CITY OF ALBUQUERQUE
MUNICIPAL DEVELOPMENT DEPARTMENT
ENGINEERING DIVISION

CONFERENCE RECAP

REF: DRAINAGE PLAN FOR BLAKE'S LOTABURGER AT MENAUL & CHELWOOD (H22-D31)

DRAINAGE STUDY
FOR
BLAKE'S LOTABURGER
MENAUL & CHELWOOD
ALBUQUERQUE, NEW MEXICO

C. 1

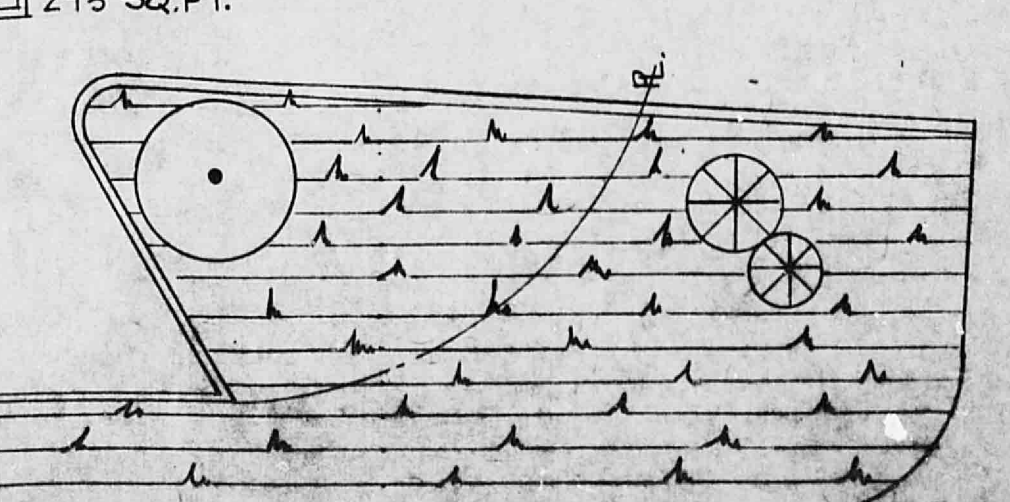
1. The pond Q_{100} water surface elevation will be identified on the plan.
2. The pond needs more detail to insure that it is constructed to the required volume and the overflow elevation is correct.
3. Pond volume calculations should be supplied to this office.
4. The maximum head permissible on the 4" PVC outlet drain is 18 inches. This pipe should project through the side of the pond.
5. The "Private Storm Drain Improvement Within City Right-of-Way" will be provided prior to the building permit sign-off.

1. Call out side slopes, on the pond, of 2 horizontal to 1 vertical (Sections A & B)
2. Mark "Revised 8/15/83" under your stamp in the upper right hand corner.

1. Enclosed are two (2) copies of the site plan on which the Q100 water surface elevation is shown.
2. We have shown two (2) cross sections of the pond for clarification to insure the construction is completed according to the designs.
3. Pond volume calculations are shown on earlier submittals and can be verified from the new cross sections.
4. We have deleted the small drop inlet to hold the maximum head on the pipe to 18".
5. I will submit the "Private Storm Drain Improvement Within City Right-of-Way" forms as soon as possible.
